Submission Form

Epping to Thornleigh Third Track Proposal. Application number SSI 5132.

Figure S.5 Artist's impression of new elevated concourse at Cheltenham Station looking south from The Crescent (indicated by dot)

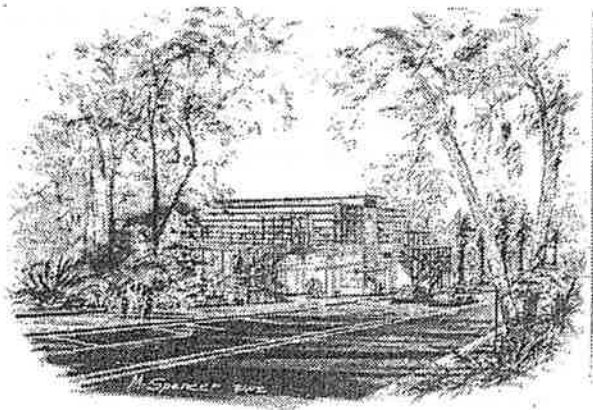
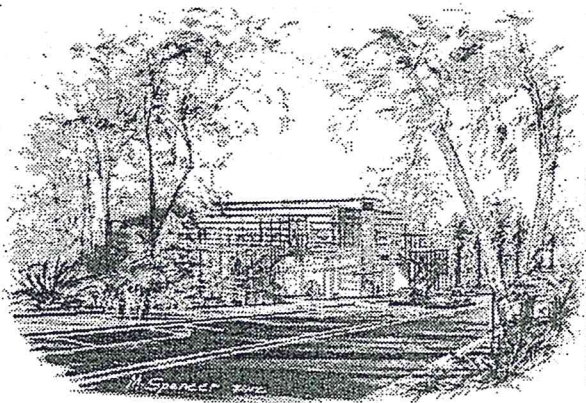
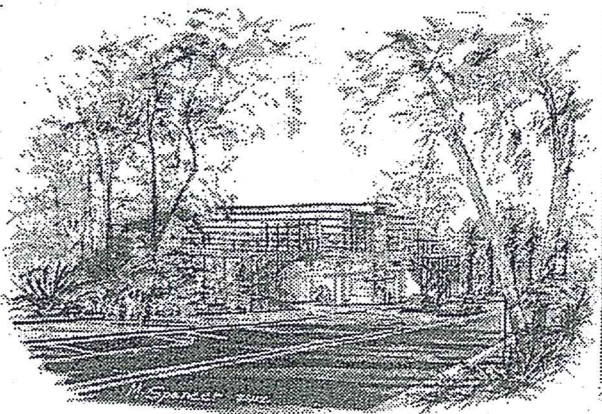
- The proposed redevelopment of Cheltenham Station shows no regard for the HCA. The visual impact of the proposed 13m high glass and steel concourse is totally unacceptable in this HCA.
